From: Laura Gibbons
Sent: 14 March 2019 12:36
To: Michael Eastham; Planning.Responses
Subject: WA/95/18/RES

Engineers Comments Regarding Surface Water Drainage

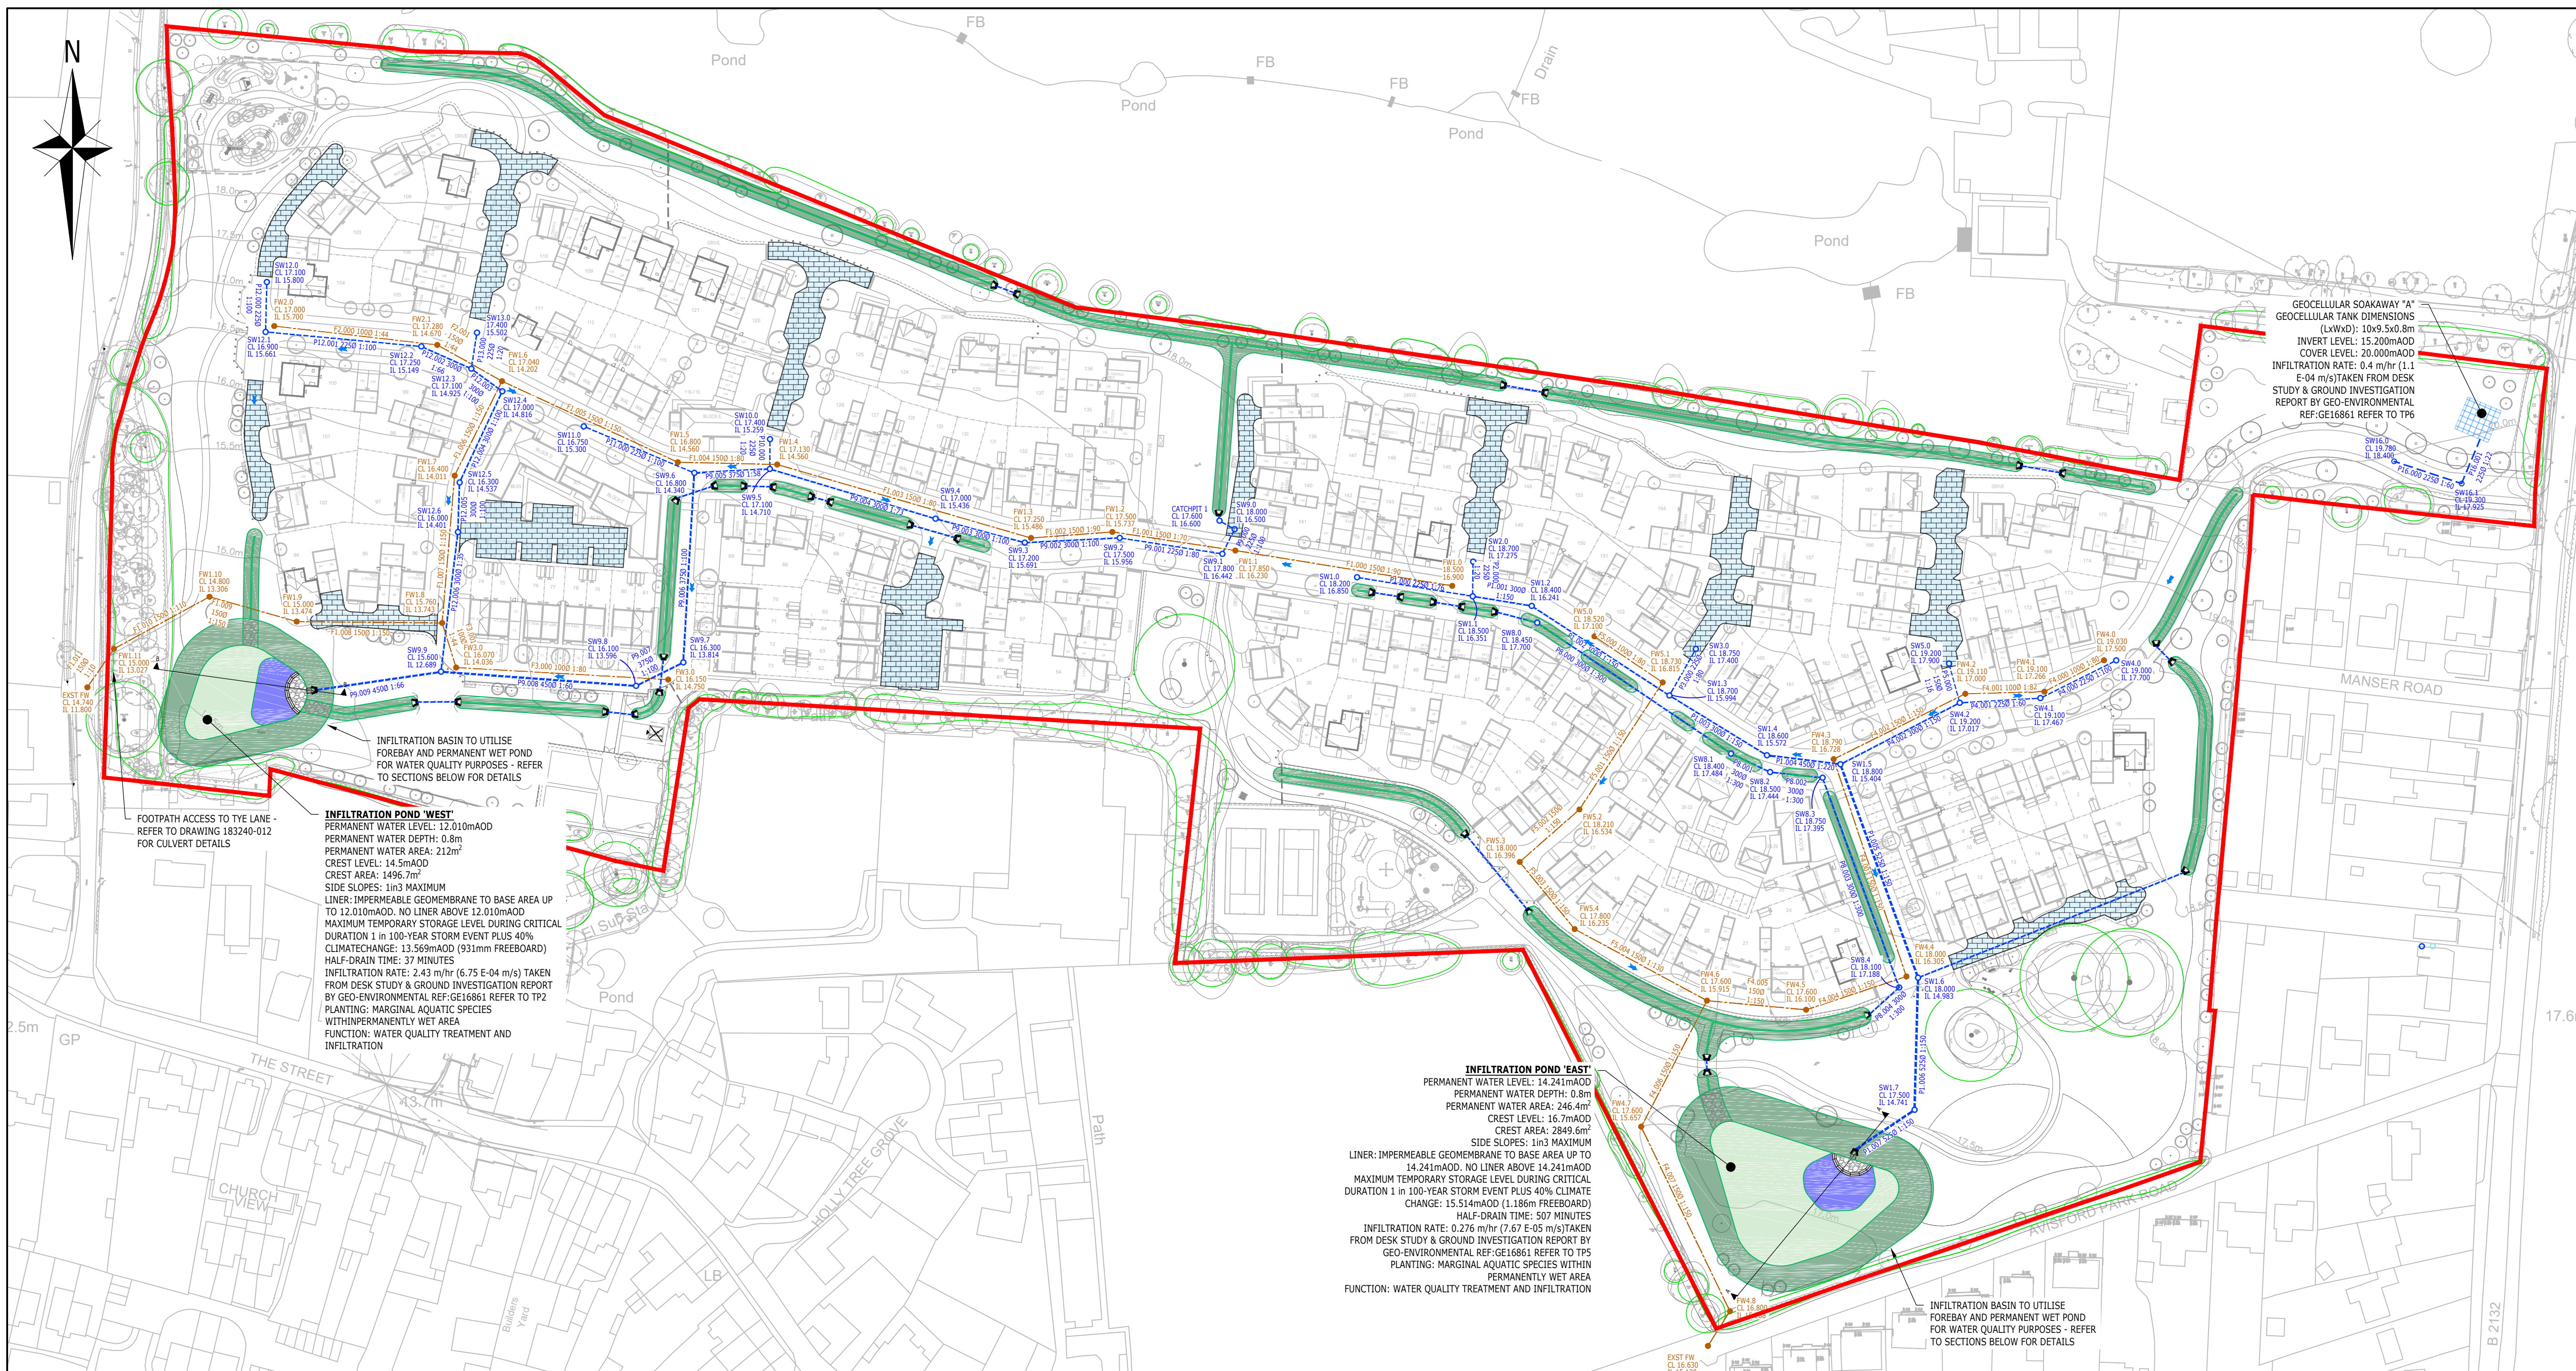
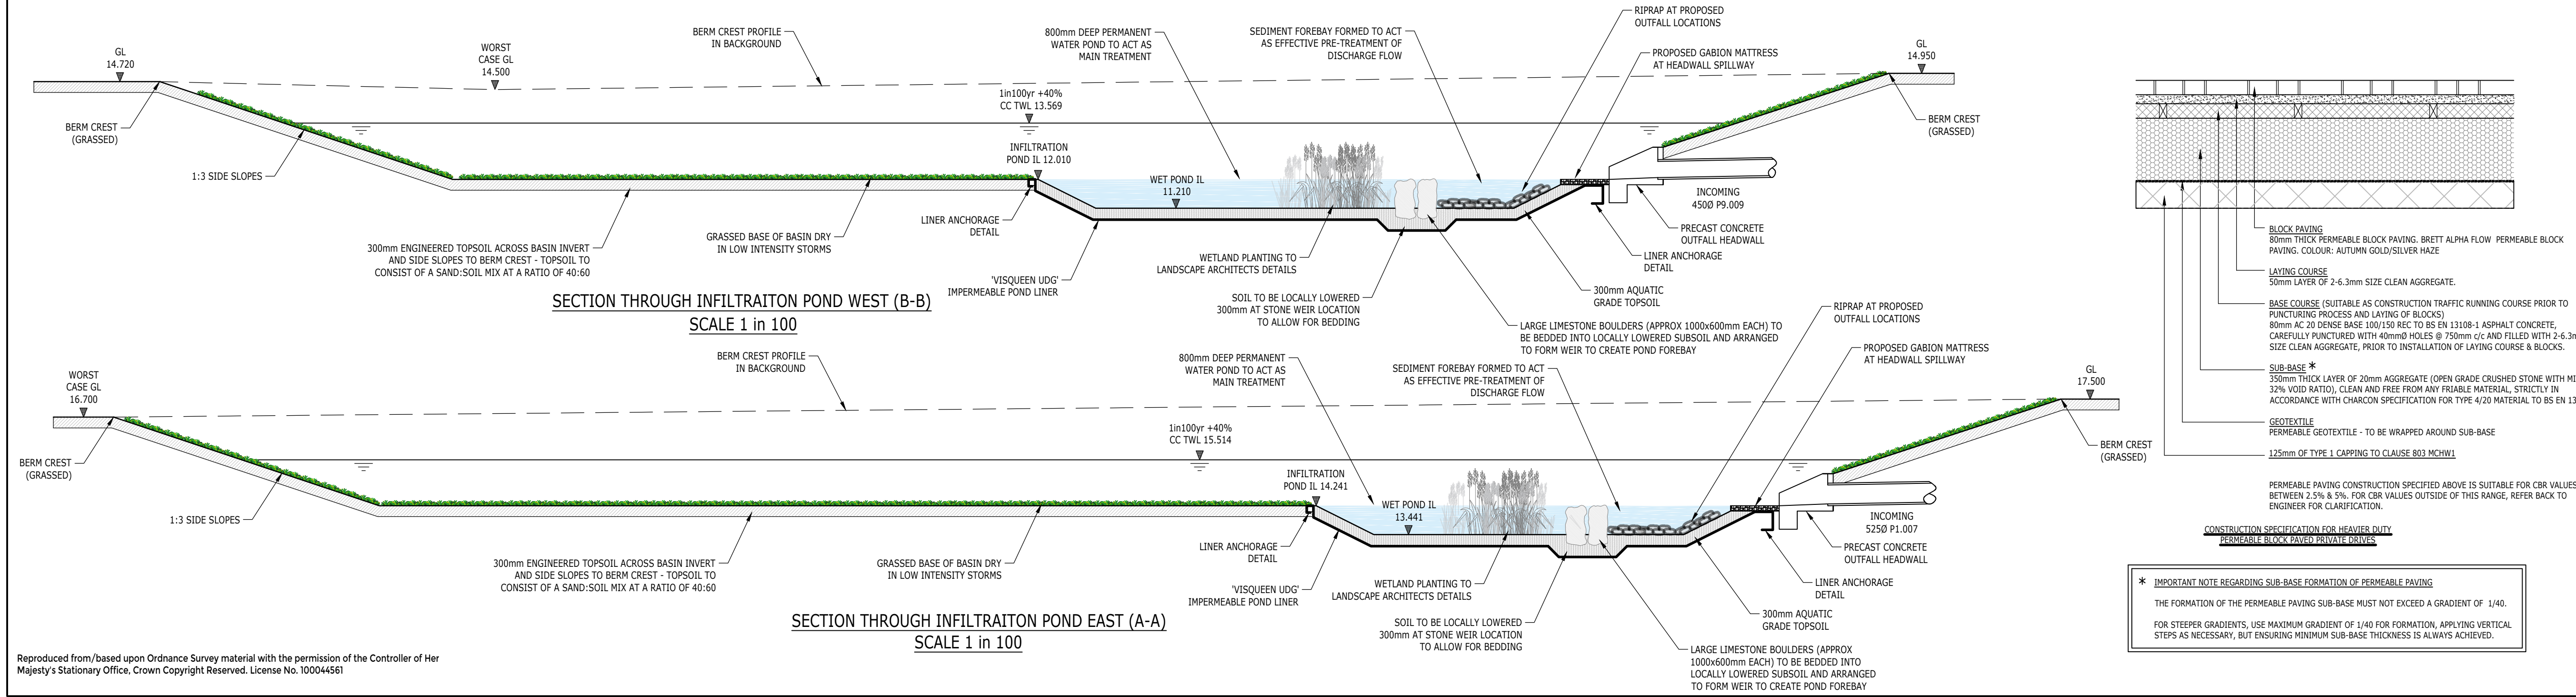
Surface water will be disposed of via infiltration; this is in line with the hierarchy for sustainable drainage. The surface water drainage design has not been finalised. However, dialogue is ongoing with the applicant's drainage engineer and the majority of the design has been resolved. Sufficient detail has been provided to allow me to have a large degree of confidence that there is adequate space within the proposed layout to facilitate surface water drainage.

In summary, I have no objection to the proposed layout. The exact details of the surface water drainage design are to be agreed via discharge of conditions application. Please ensure that no detailed drainage plans are listed as approved under this application.
